# CITY OF ALBUQUERQUE

**RE: International School at Mesa Del Sol – Phase 8  
Grading Plan  
Stamp Date: 8/29/17  
Hydrology File: R16DA3009**

Based upon the information provided in your submittal received 8/29/17, the Grading Plan **is not** approved for Foundation Permit and Grading Permit. The following comments need to be addressed for approval of the above referenced project:

C-101

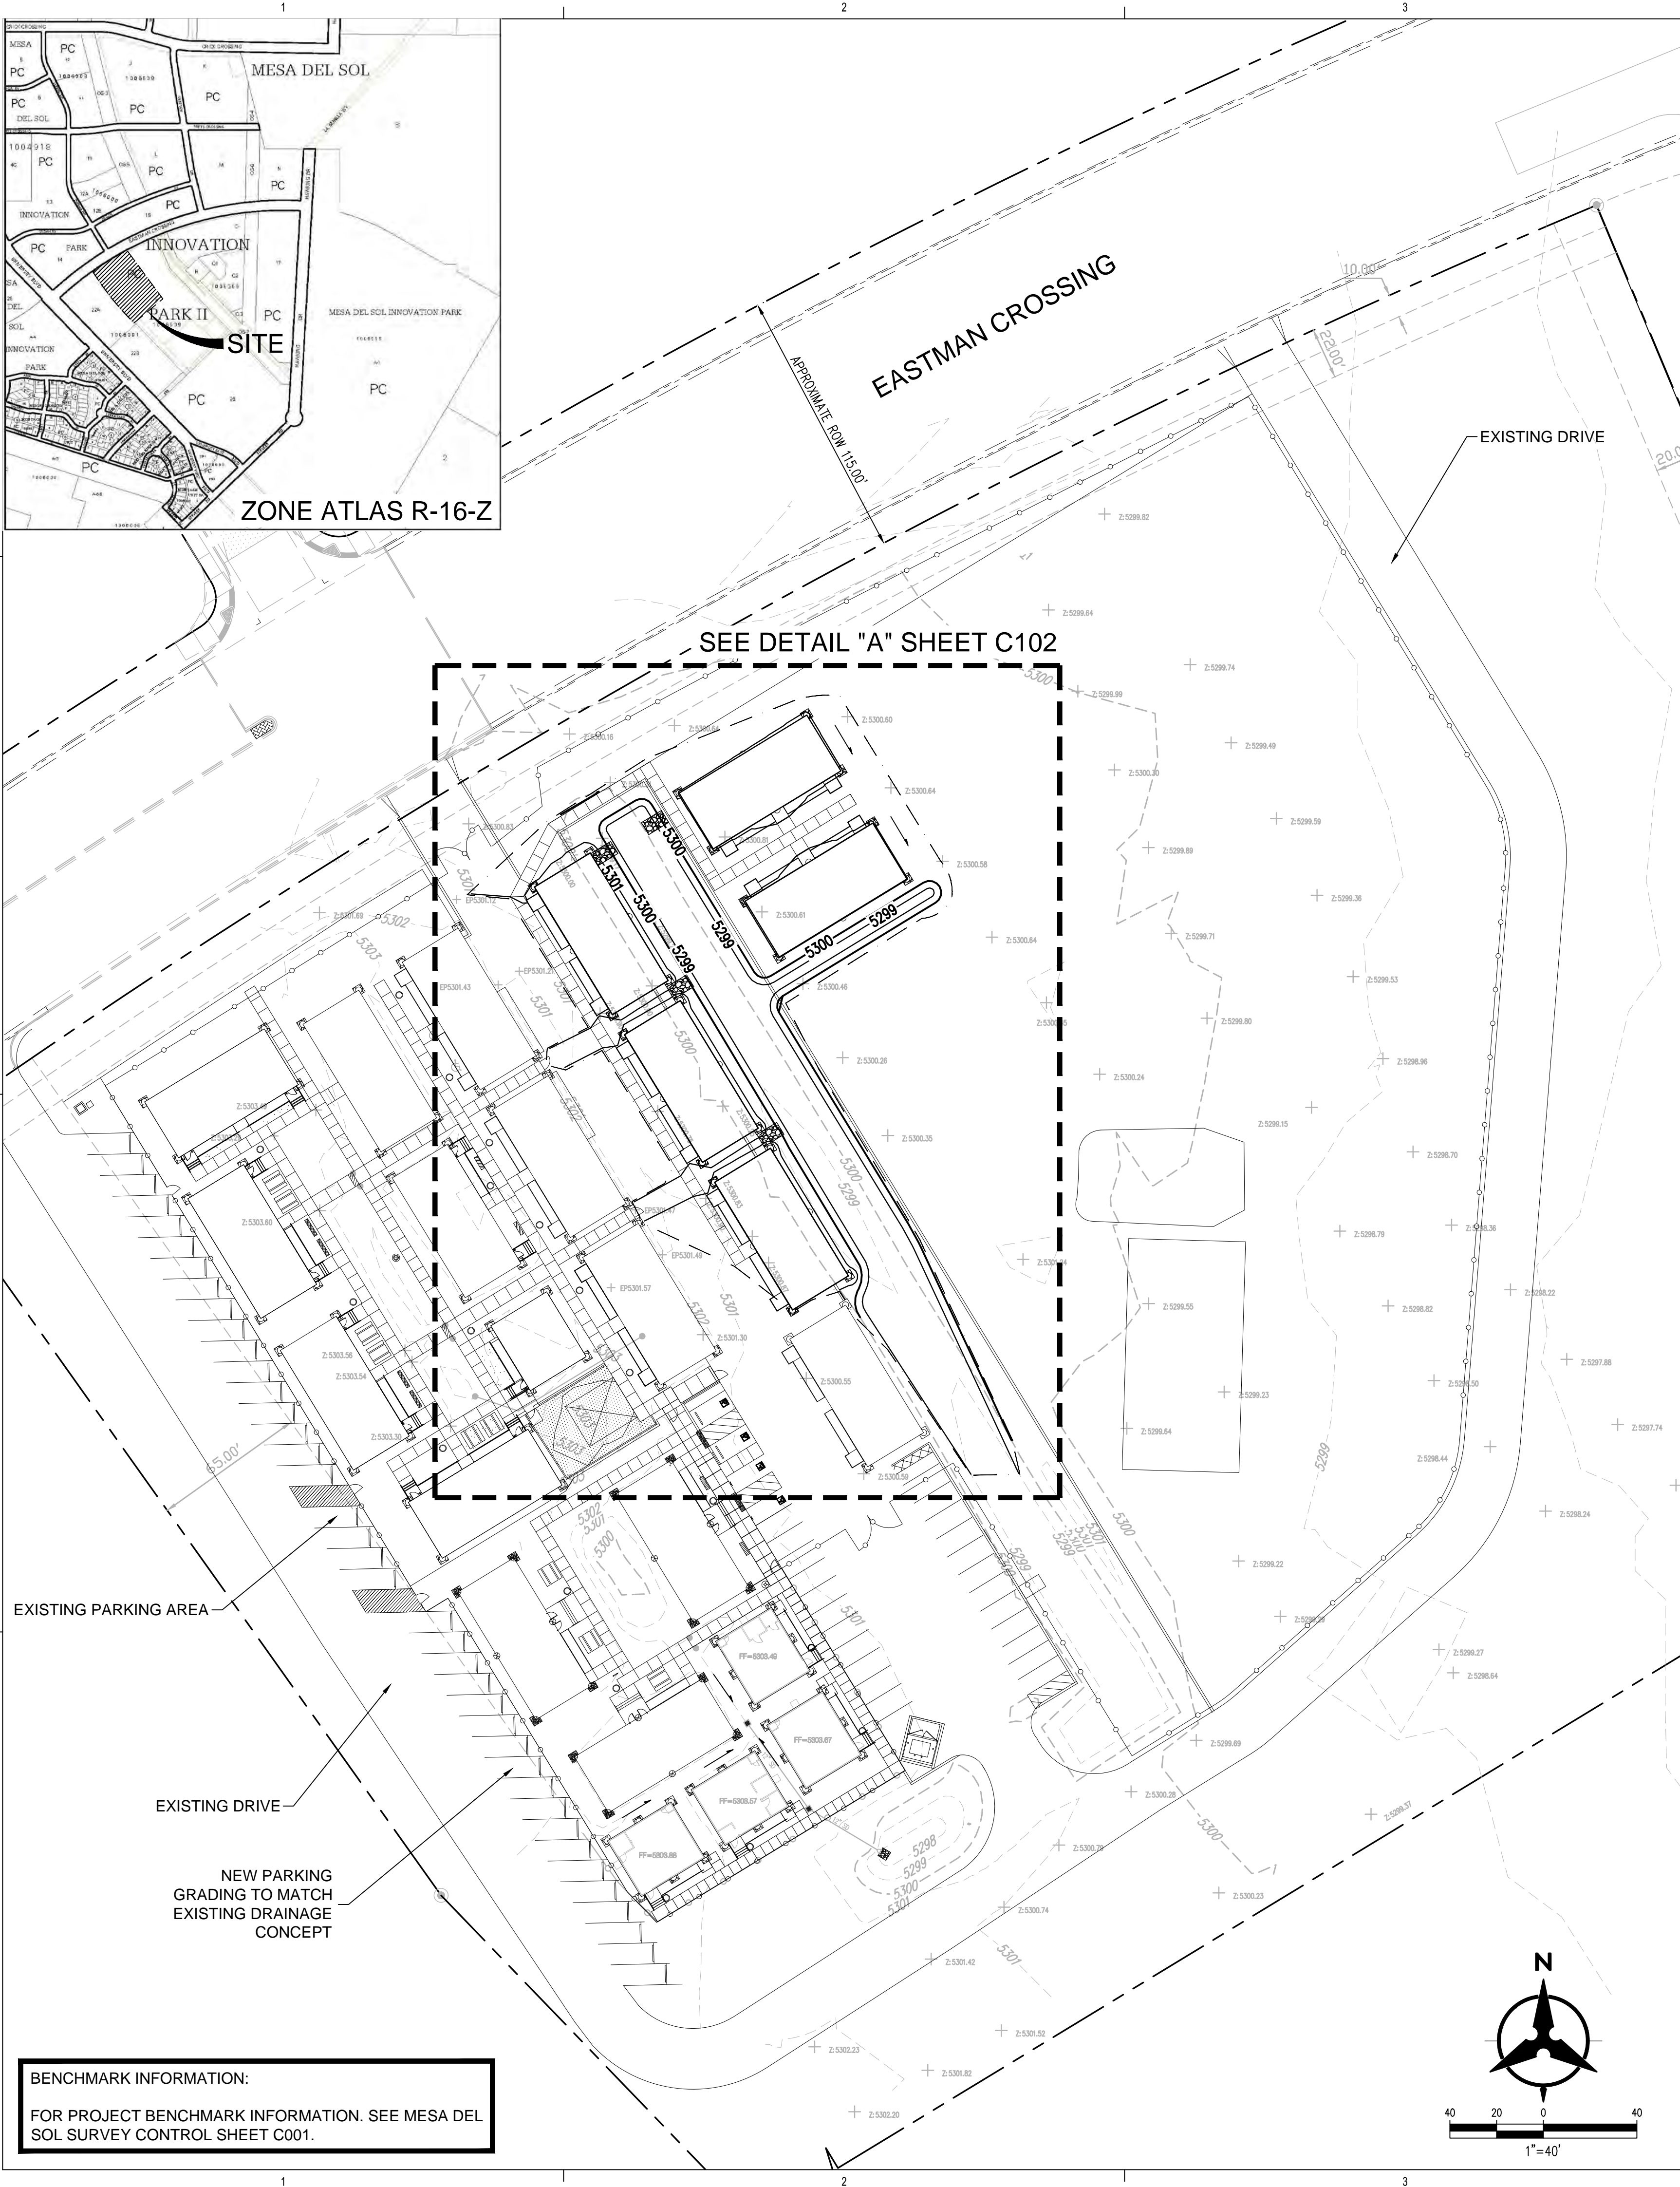
1. Please add "Phase 8" to the Project Title.
2. Please provide a vicinity map.
3. Please provide the flood plain note with effective date.
4. Please provide the benchmark information for the survey information provided.
5. Under Drainage Management. Please change the last sentence to read, "Existing Drainage Management Plan with engineer's stamp date of 7/18/12 ...remains unchanged."
6. Please provide the hydrology calculations for proposed development. The 2 year 24 hour pond volume should be included.
